Re: Re-submission of details to discharge Condition 9 and 27 of planning permission Y/91/17/OUT

This covering letter accompanies the application and supporting documents submitted online through the Planning Portal under the reference: PP-11291128, which relates to the re-submission of details to support the discharge of Condition 9 and 27 of planning permission Y/91/17/OUT at Land at Bilsham Road, Yapton.

Engineers Comments Regarding Condition 9

Drawing Status FOR APPROVAL

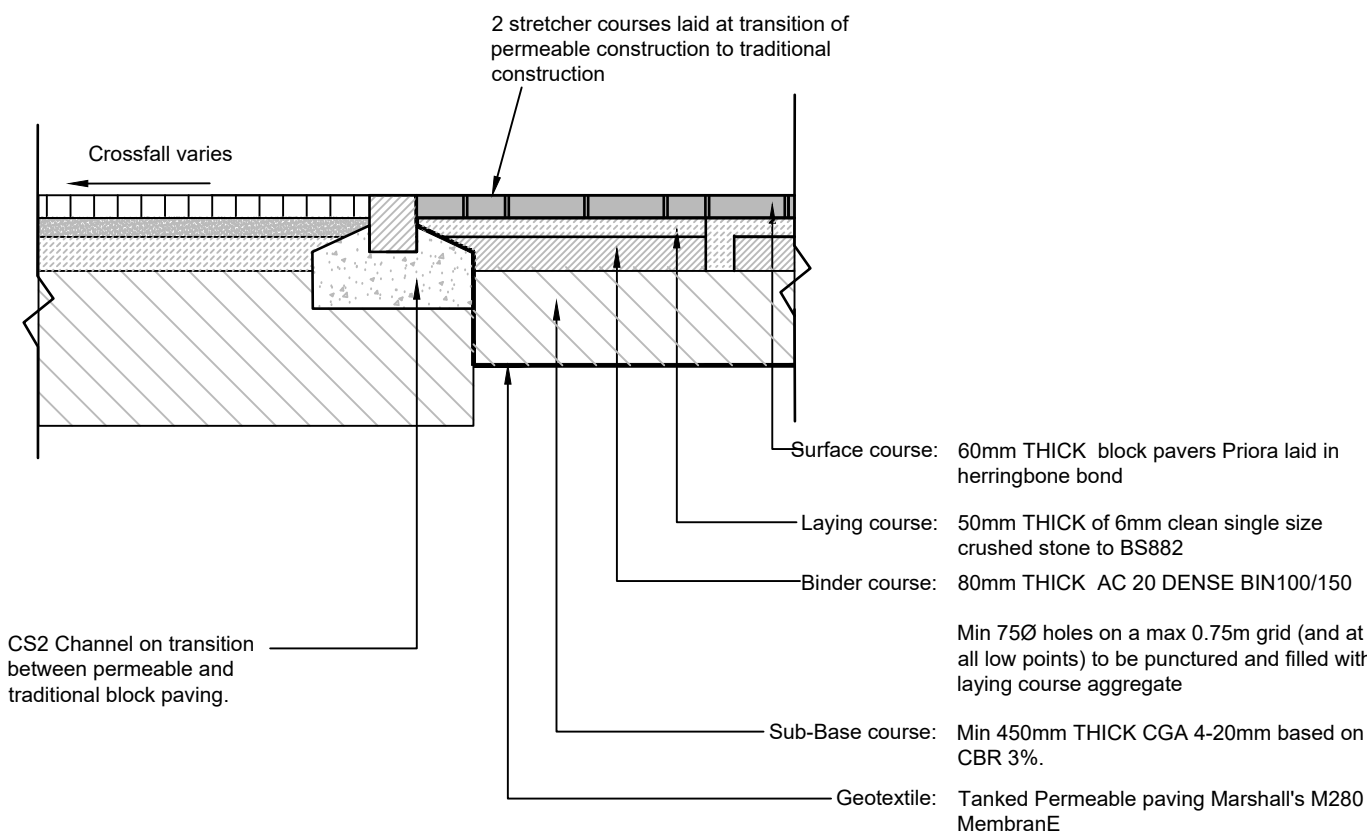
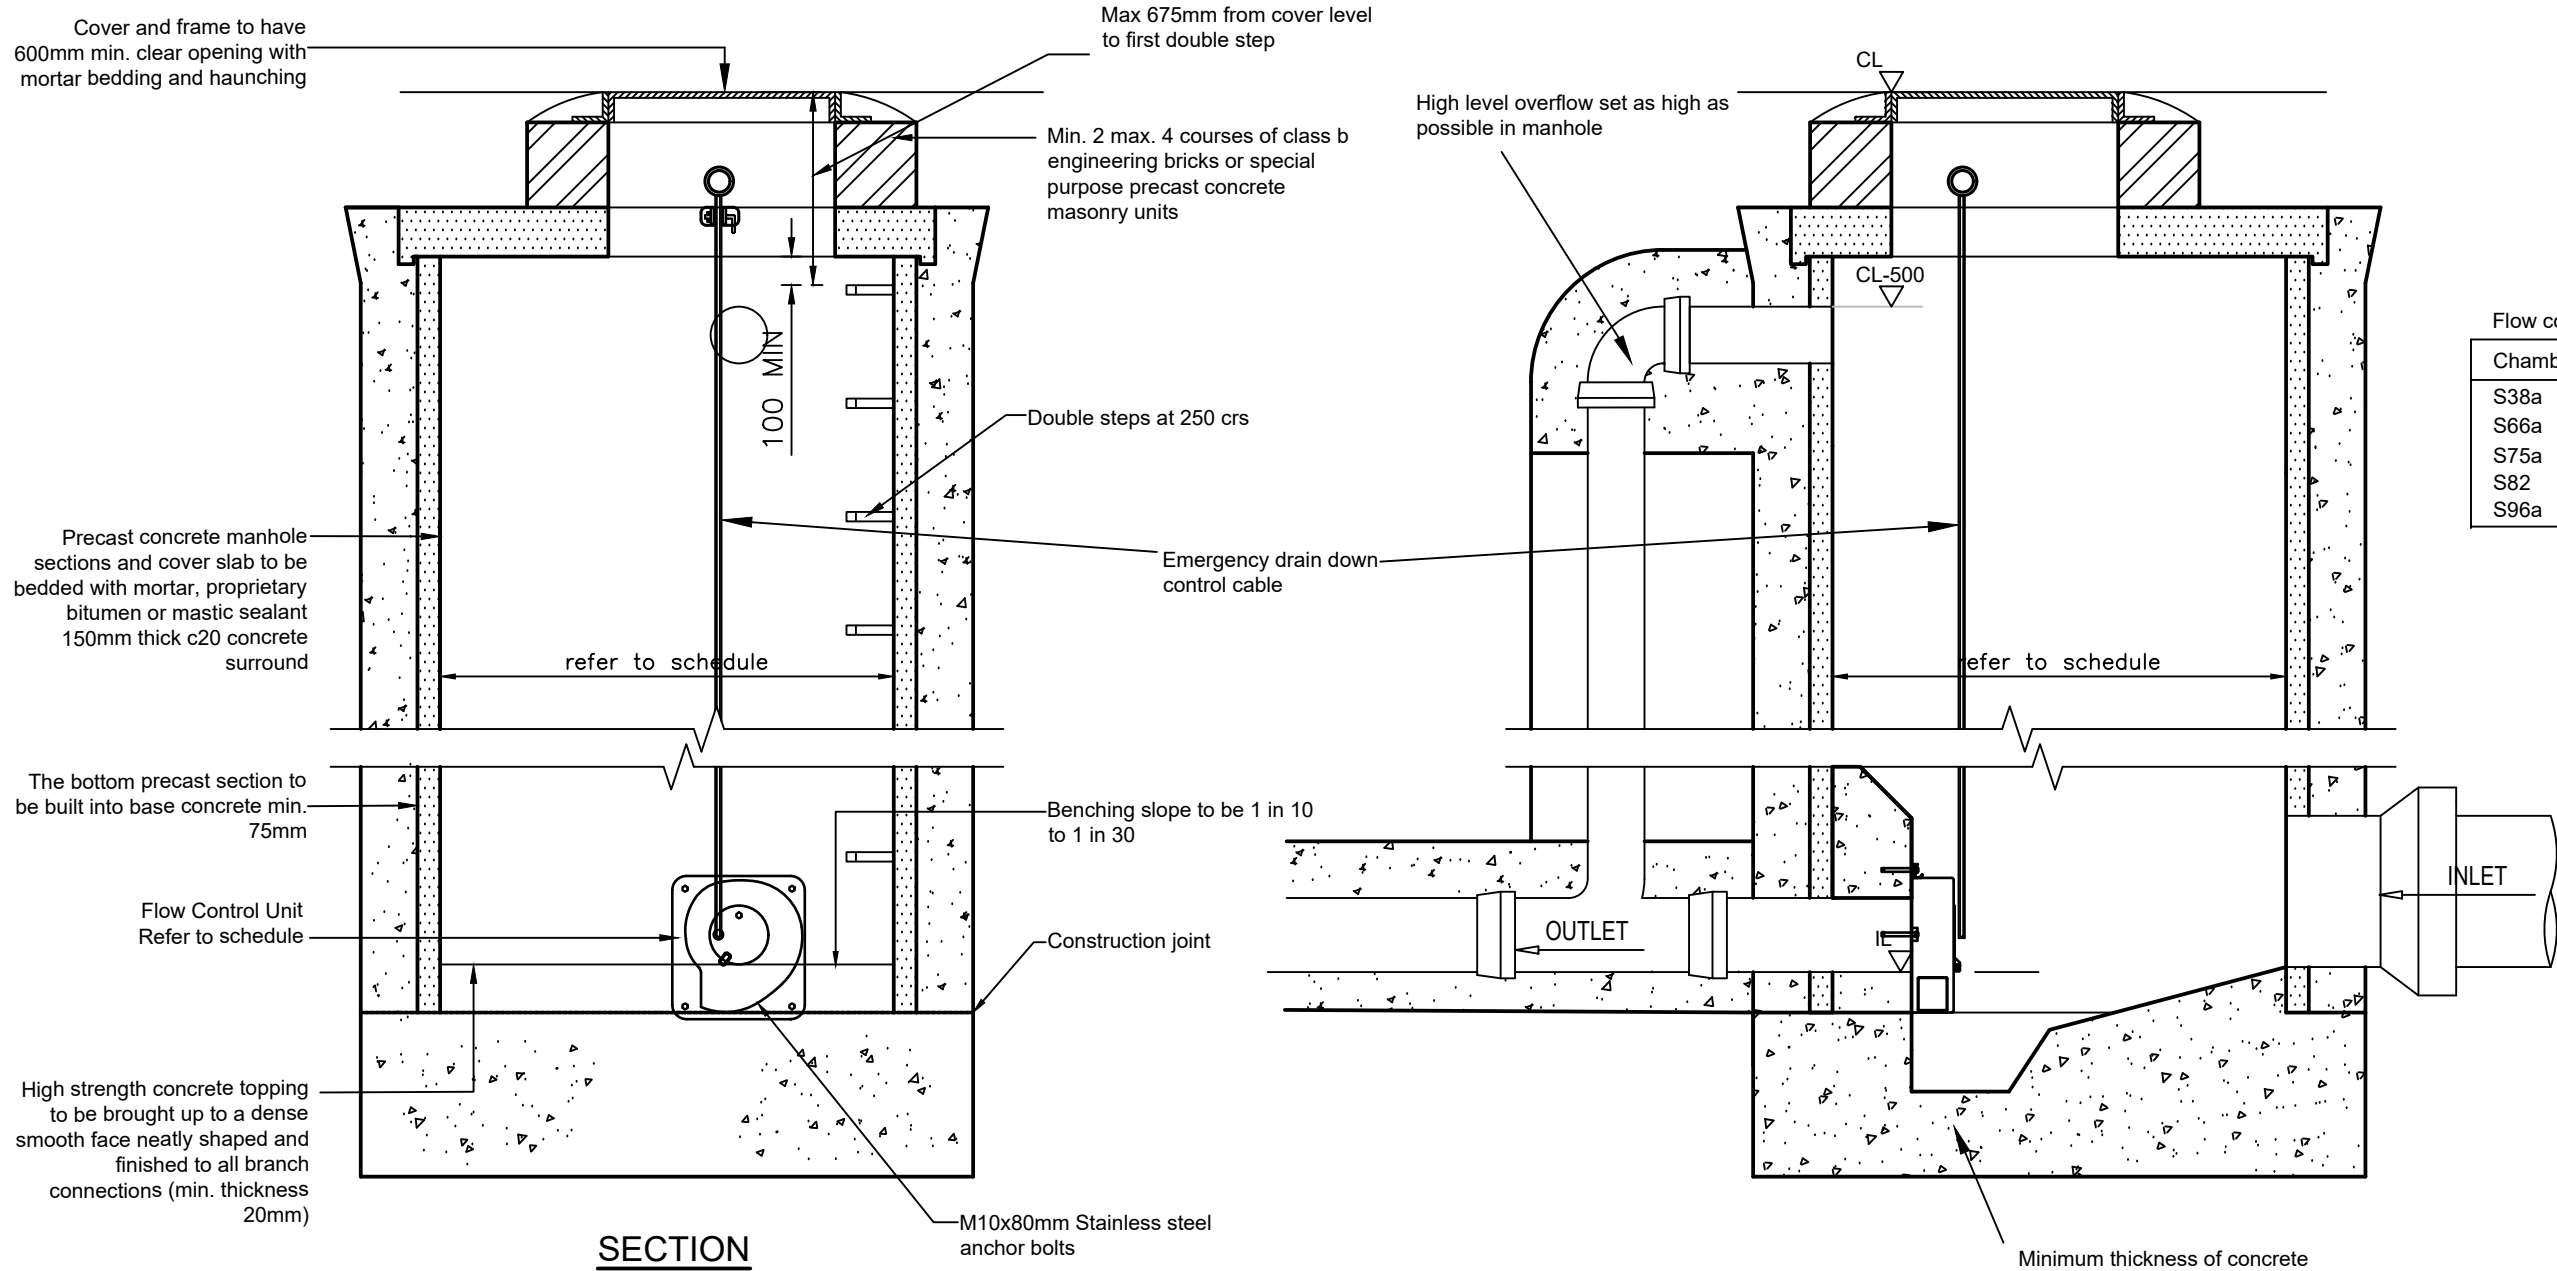
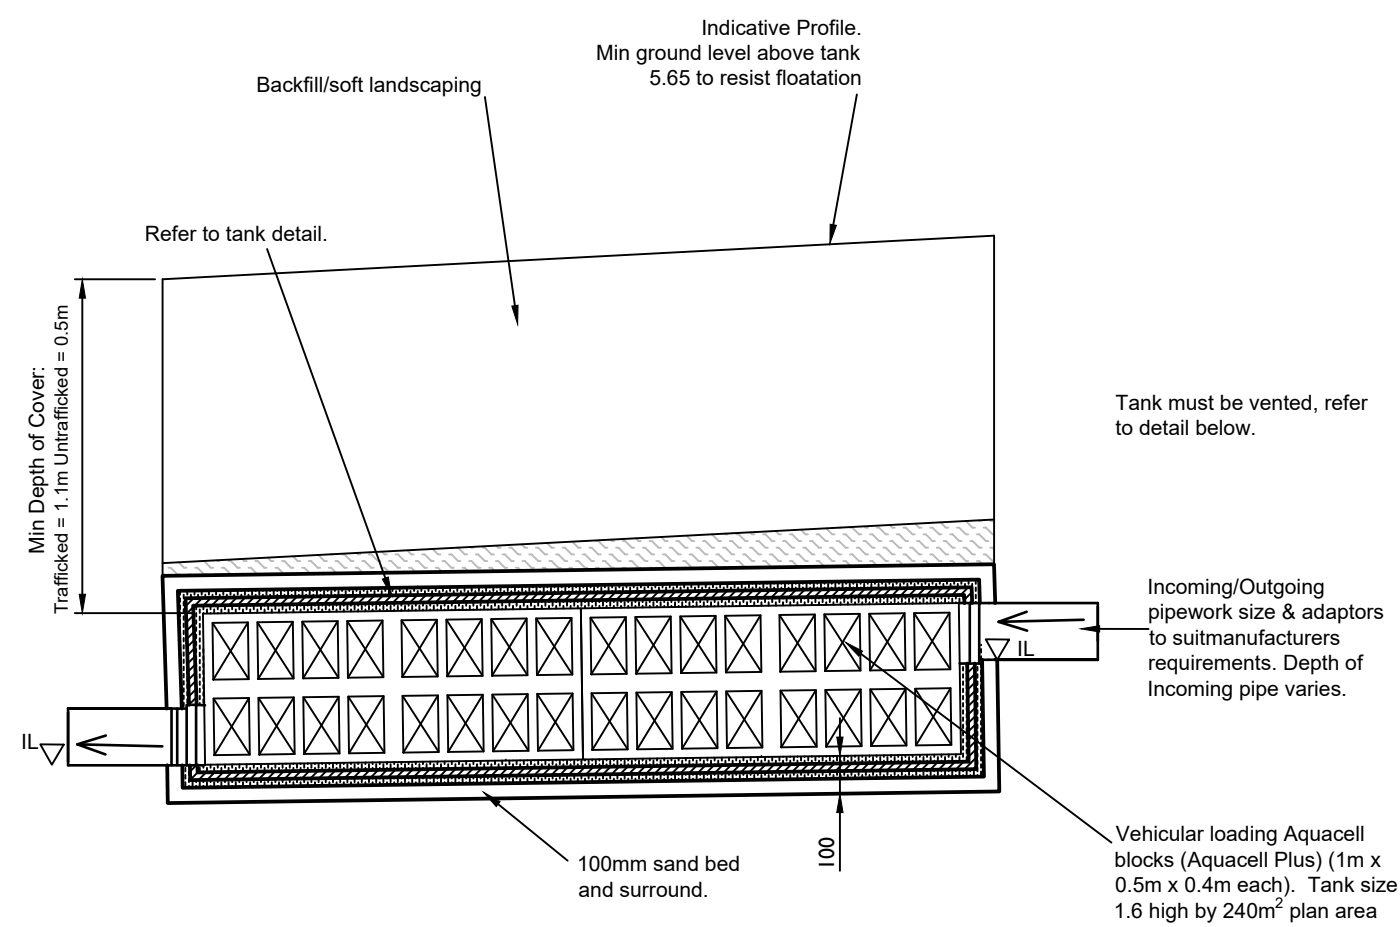
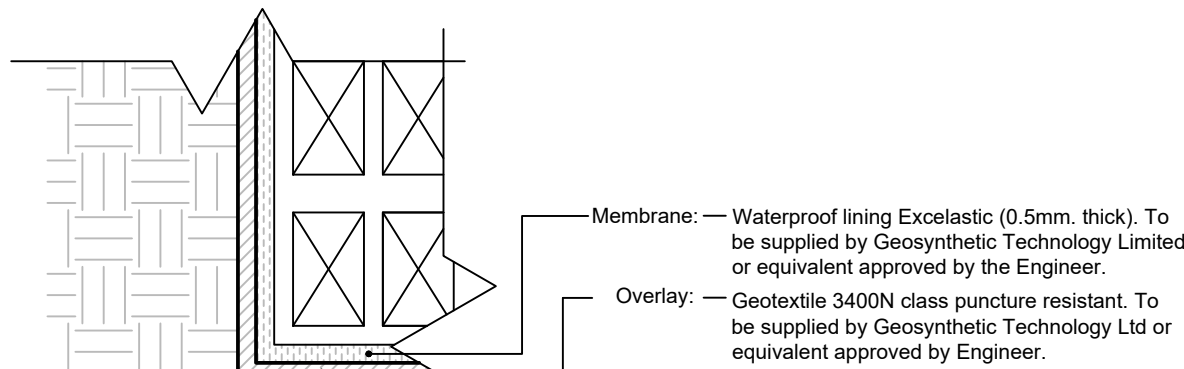
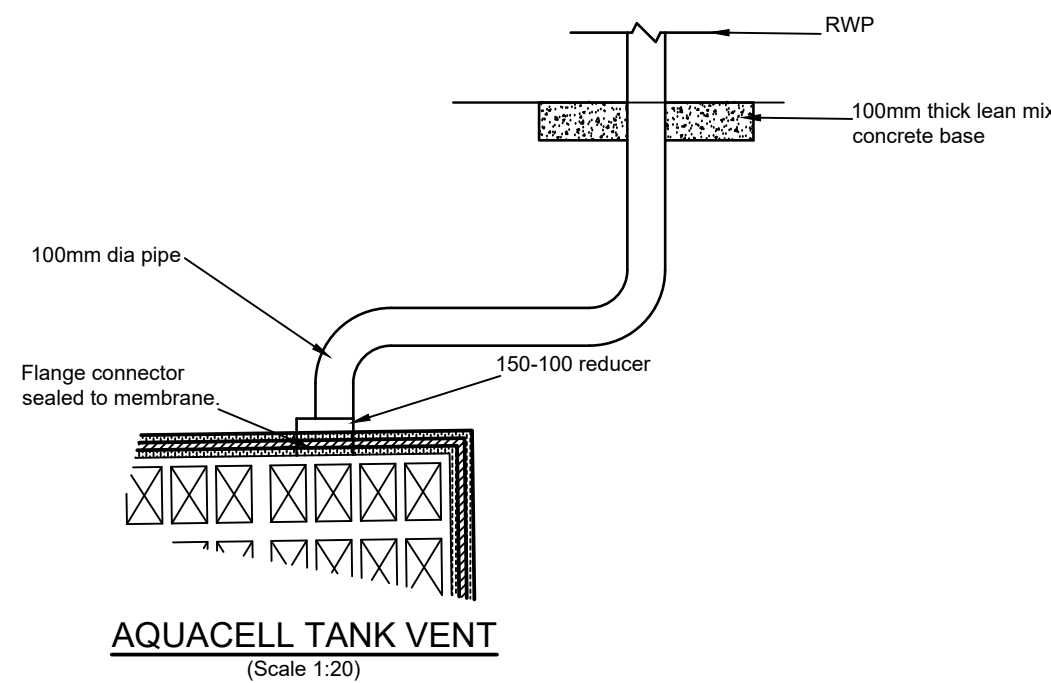
11. Please provide cranked grilles at a 45 degree angle.
12. Please detail invert levels of hydrobrakes and invert levels of overflows for each flow control device on the detail drawing.

13. There are inconsistencies between layout and details for the attenuation tank. Layout states a depth of tank of 1.5m but detail states a depth of 1.6m. Please ensure consistency.

16. Please provide a construction detail of permeable paving which clearly defines the construction, i.e. blocks, bedding, membranes, sub-base, tanking membrane. Materials and depths should be clearly defined.

11. Please provide cranked grilles at a 45 degree angle. – This is not DCG compliant.
12. Please detail invert levels of hydrobrakes and invert levels of overflows for each flow control device on the detail drawing. These details have now been added to drawing D1956-15-3A

13. There are inconsistencies between layout and detail for the attenuation tank. Layout states a depth of tank of 1.5m but detail states a depth of 1.6m. Please ensure consistency. – This has been corrected on the layout.

16. Please provide construction detail of permeable paving which clearly defines the construction, i.e. blocks, bedding, membranes, sub-base, tanking membrane. Materials and depths should be clearly defined. – This has been added to drawing D1956-15-3A.

Drawing Status	FOR APPROVAL						
Client	THAKEHAM						
Project	BILSHAM ROAD YAPTON						
Drawing Title	PROPOSED PERMEABLE PAVING FORMATION LEVELS AND DIFFUSERS						
Scale	1:500	Date	Feb 22	Drawn By	LDF	Checked By	MJA
Drawing No.	D1956-13-300	Rev.	A

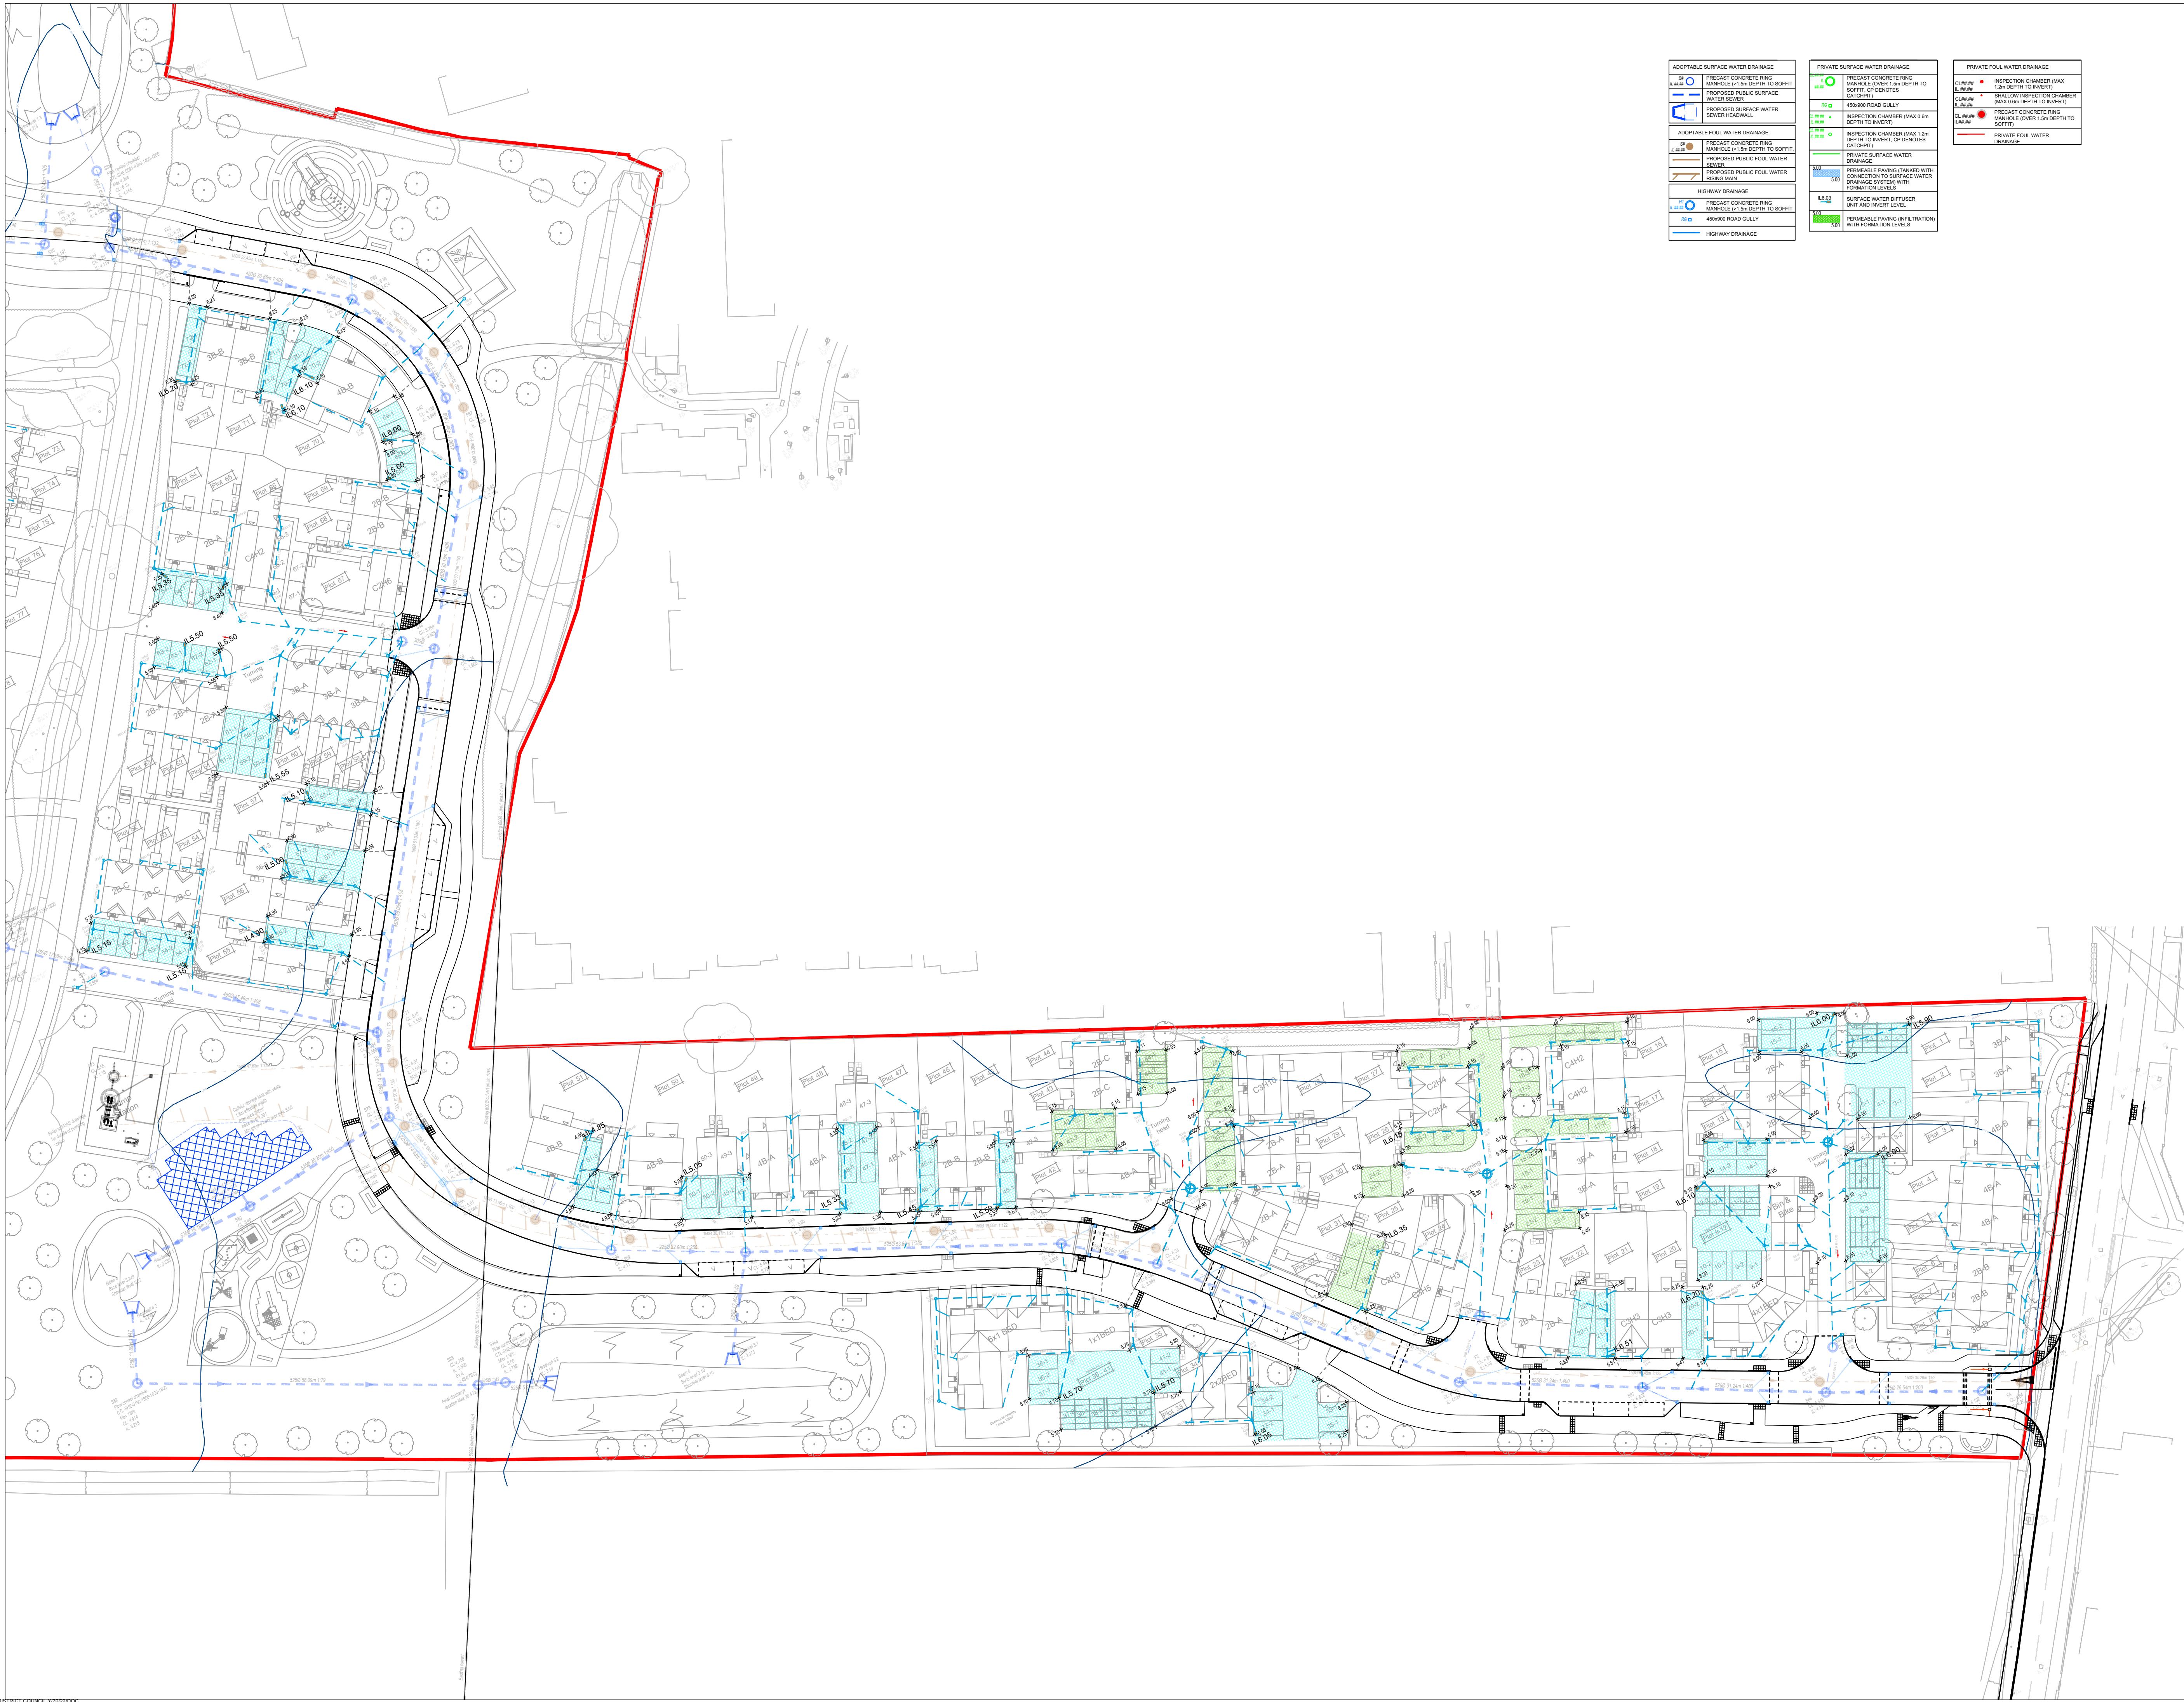
1. Please provide a layout plan showing the locations and results of groundwater monitoring and infiltration testing.
2. Please provide greenfield runoff rate calculations for the proposed impermeable area which is positively drained.
3. Please provide catchment impermeable areas diagrams.
4. Please provide exceedance flow drawings.
5. Please detail hydrobrake unit references on layout and details.
6. Please provide calculation printouts of inputs to calculations which include pipes and manholes.
7. Please ensure consistency between calculations and layouts.
8. Please clearly label finish and formation level of all permeable paving areas.
9. Please label cover levels of gullies.

14. Please provide catchpits upstream of attenuation tanks and basins (unless basins are to have sediment forebays).
15. Please clearly show location of diffuser tanks in permeable paving, and connections of these to the drainage network. Please label diffusers with invert level.

8. Please clearly label finish and formation level of all permeable paving areas – see drawings D1956-13-300, D1956-13-301 and D1956-13-302
9. Please label cover levels of gullies – Please refer to the levels drawings D1956-13-200A, D1956-13-201A to D1956-13-202A

14. Please provide catchpits upstream of attenuation tanks and basins (unless basins are to have sediment forebays). – This is not DCG compliant.
15. Please clearly show location of diffuser tanks in permeable paving, and connection of these to the drainage network. Please label diffusers with invert level. – see drawings D1956-13-300, D1956-13-301 and D1956-13-302
